From: Chris.Ritchie@planning.nsw.gov.au
Sent: Tuesday, 26 July 2016 2:55 PM
To: Reg Van Rij
Cc: rebecca.sommer@planning.nsw.gov.au
Subject: Fencing

In response to your letter regarding the fencing at Cobaki, I understand that the Fencing Plan (Fencing Plan Precinct 9, 11 and SSP) forms part of the Project Approval for the site. This condition formed part of the modification 2 request to ensure that the boundaries of rehabilitation and covenant protected areas are appropriately surveyed, marked with high visibility fencing (which is, in some areas, permanent) and protected.

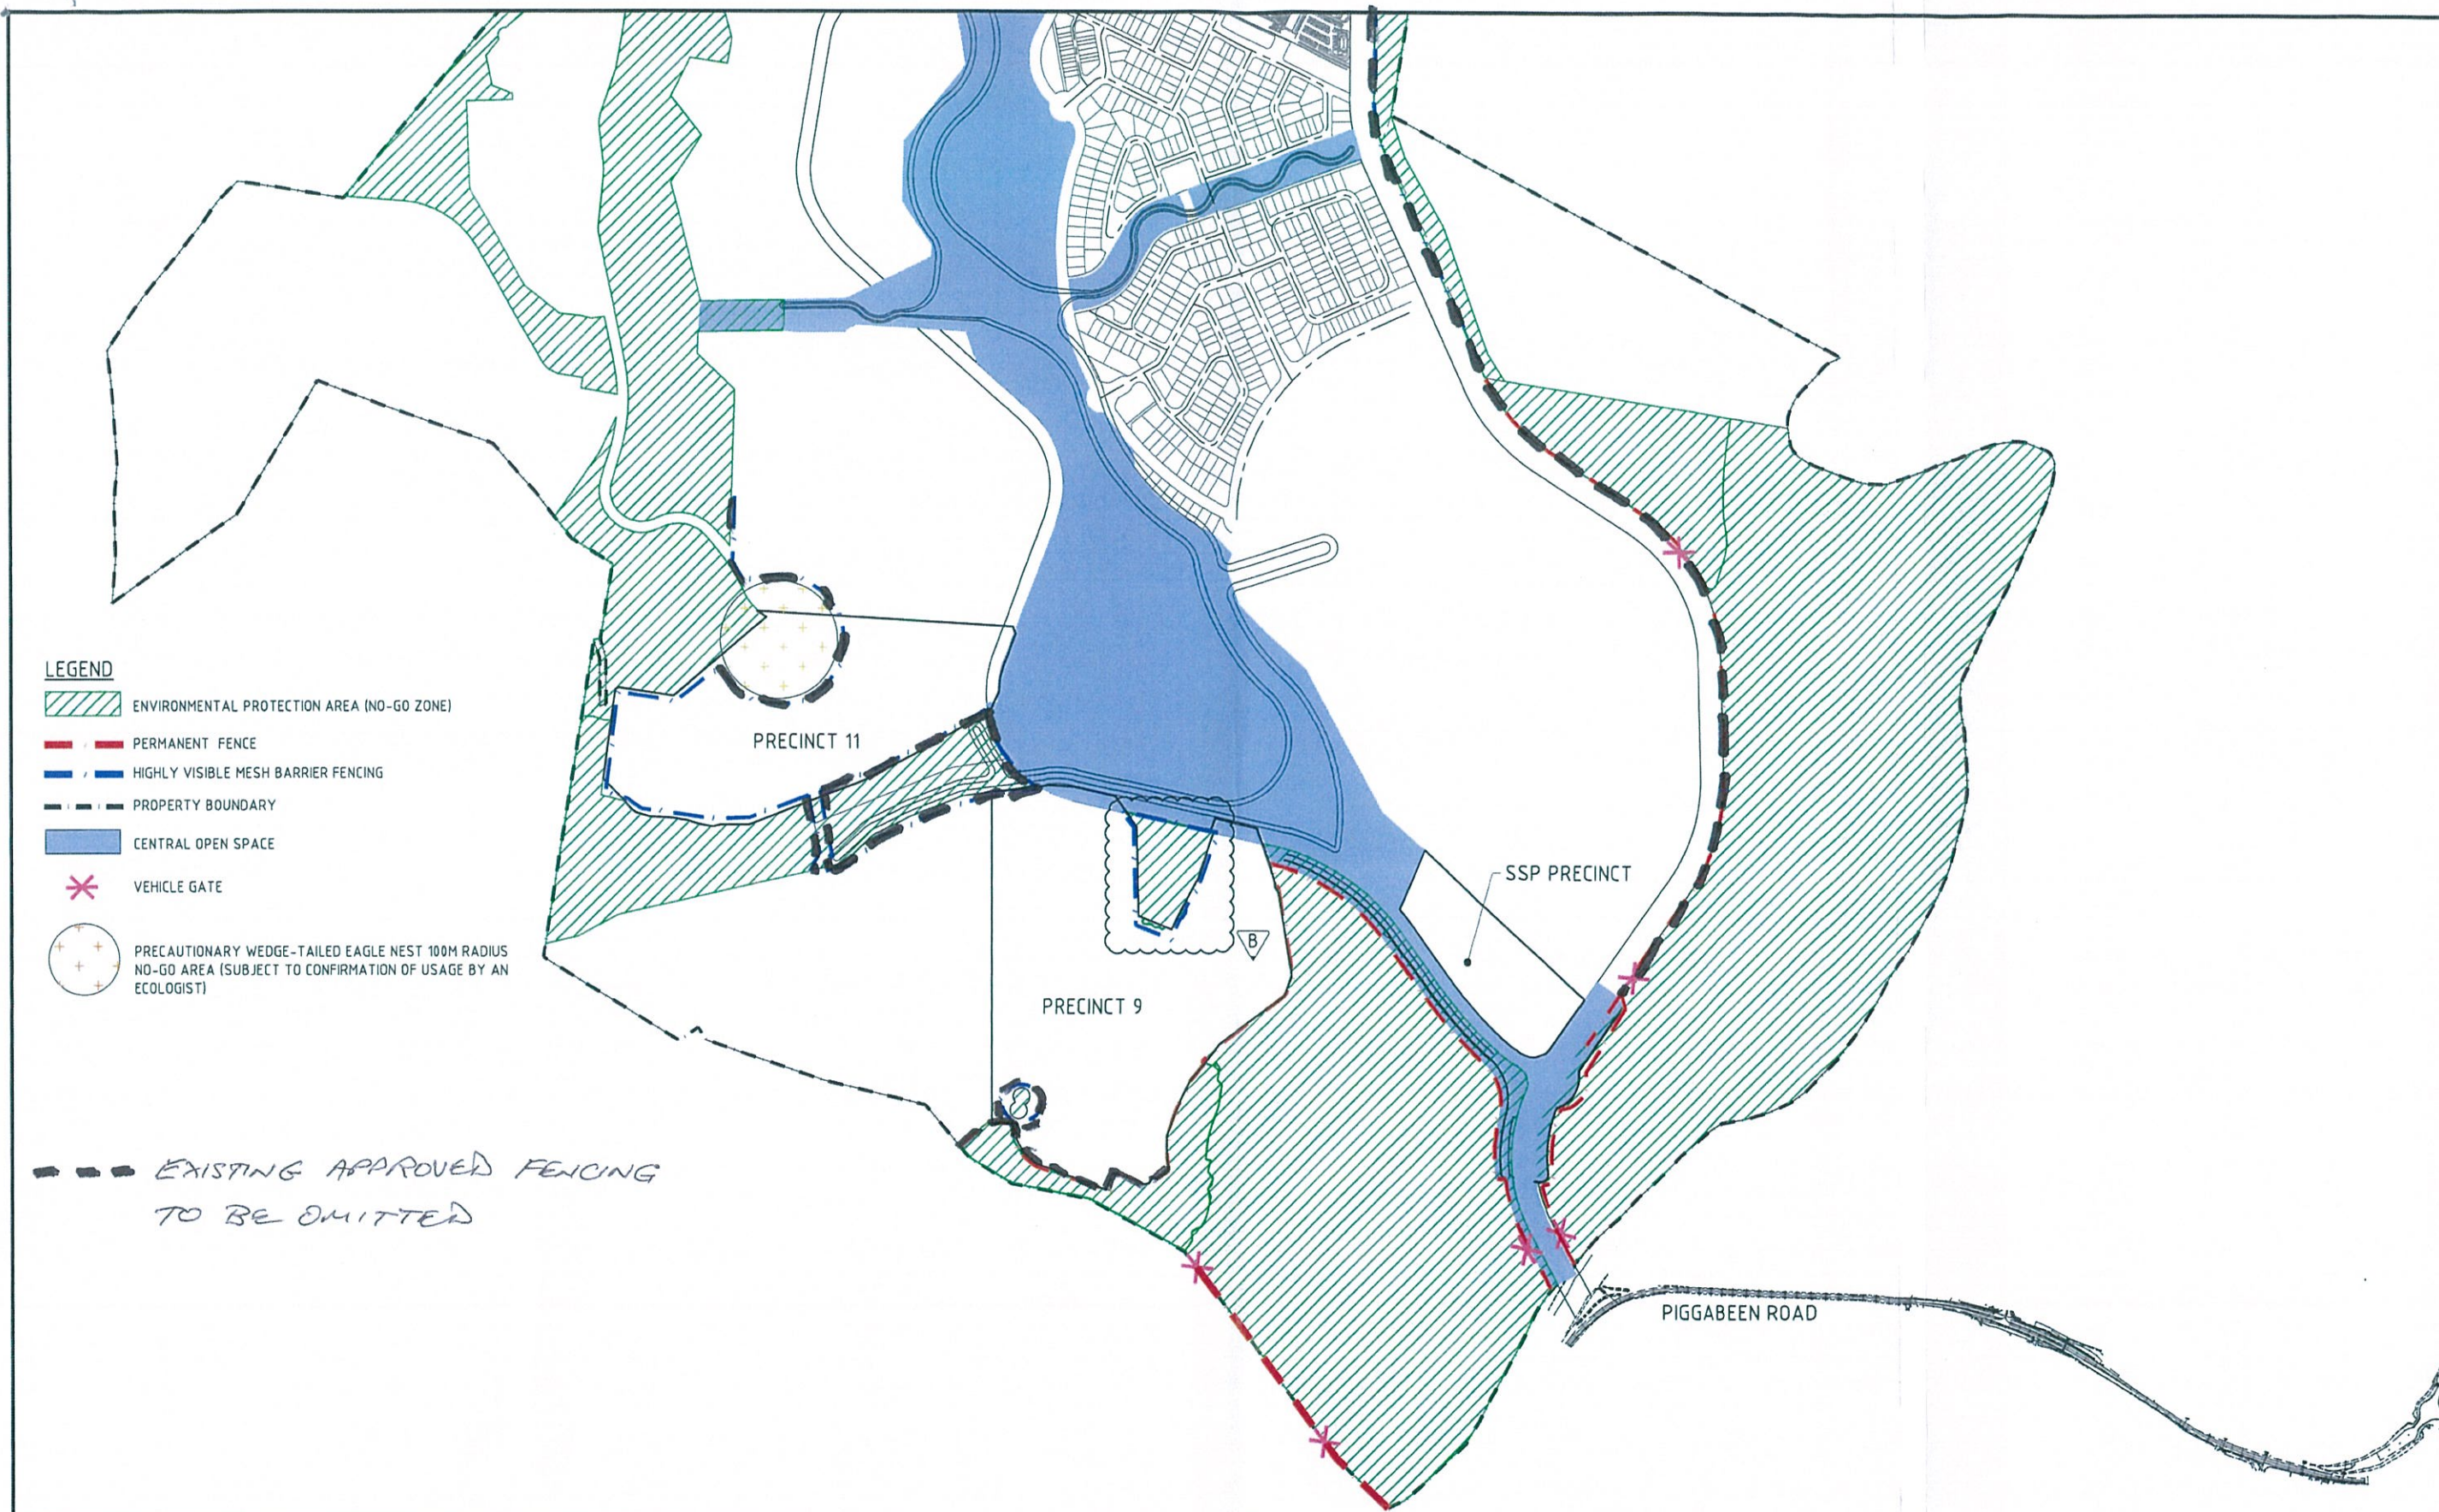
With regards to the indicative plan provided on 20 July 2016, I am presently of the view that fencing of the environmental zones adjacent to Precincts 9 and 11 should remain given that works are presently occurring in these areas. With regards to the fencing along Cobaki Parkway, the need for the permanent fencing to delineate the working areas vs. 'other' areas seems critical.

If significant modification to the fencing plan is required, the Department requests justification and detail of how works would be managed without the delineation of 'no go areas' by a fence.
